Arun District Council
Arun Civic Centre
Maltravers Road
Littlehampton
West Sussex BN17 5LF
Planning & Building Control General Enquiries
Tel: (01903) 737756 Fax: (01903) 730442
Dx: 57406 Littlehampton
Minicom: 01903 732765
e-mail: planning@arun.gov.uk
website: www.arun.gov.uk/planning

Application No: R/89/22/HH
Site Address: 75 Chaucer Avenue Rustington BN16 2PG
Description of works: Single storey rear extension and conversion of loft to habitable use including the installation of 1 x rear dormer and 3 x front rooflights.

Thank you for your internet representation made on 16th May 2022 which has been recorded as an objection with the comments as follows:

Drawing Title:
PROPOSED ELEVATIONS

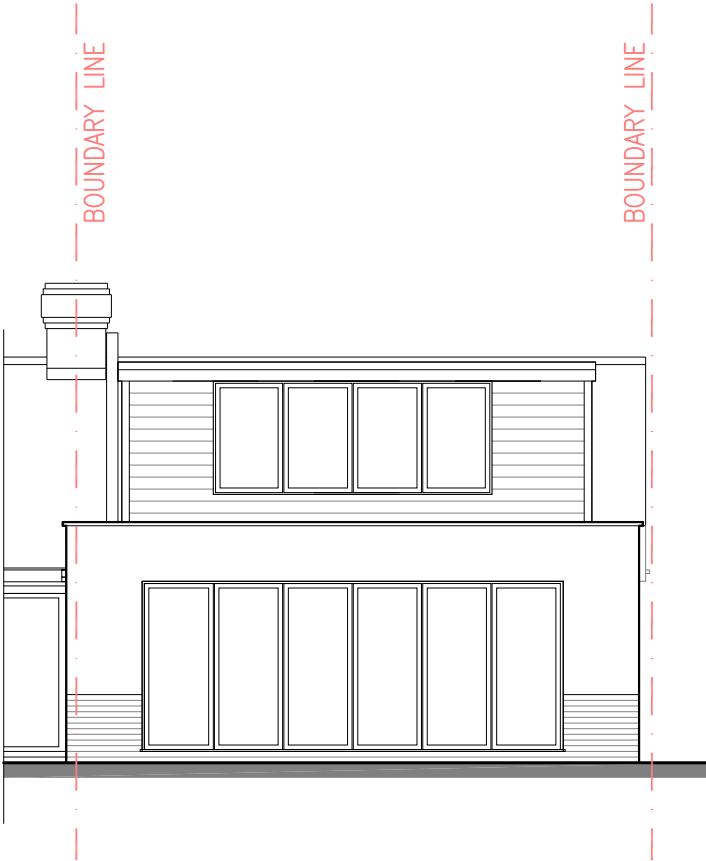
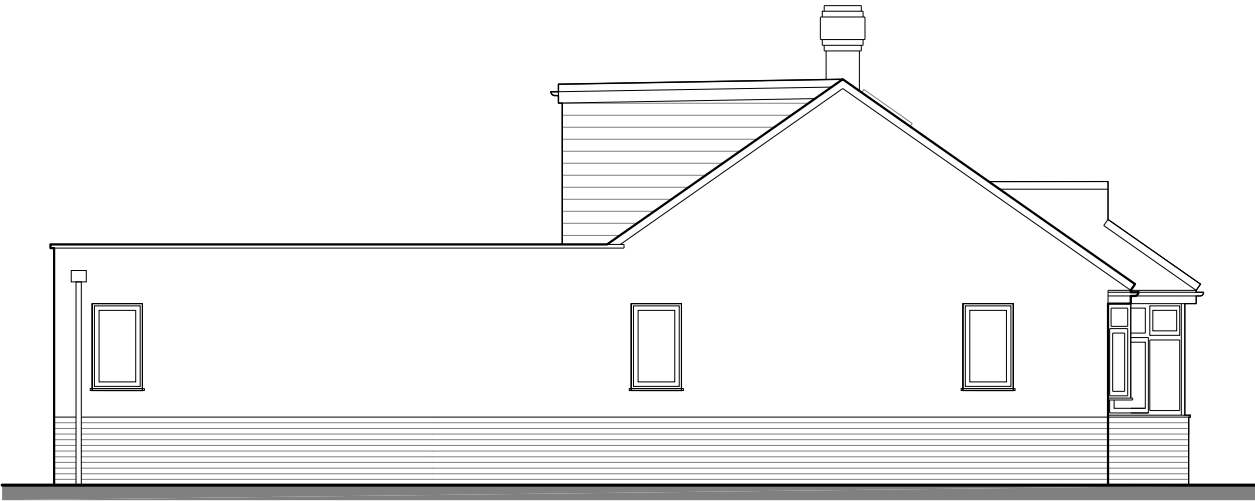
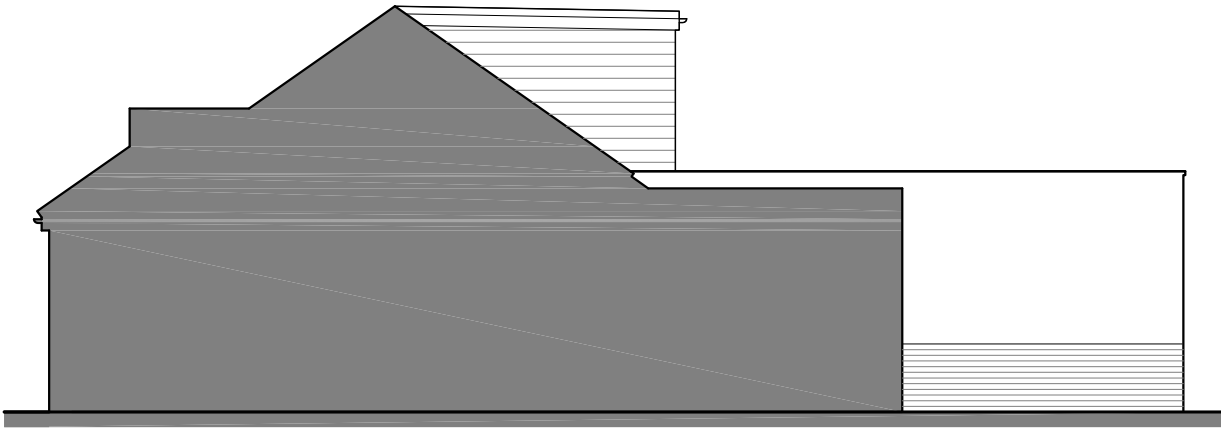
Following my original comment, I have looked at the front elevation where there will be roof lights and spoken to others who have these in this area to determine what can be seen. The proposed roof lights at 75 will allow the occupant to look into my bedroom if not high enough, I do not want to have to keep my blinds shut. Please take this into consideration. Thank you.
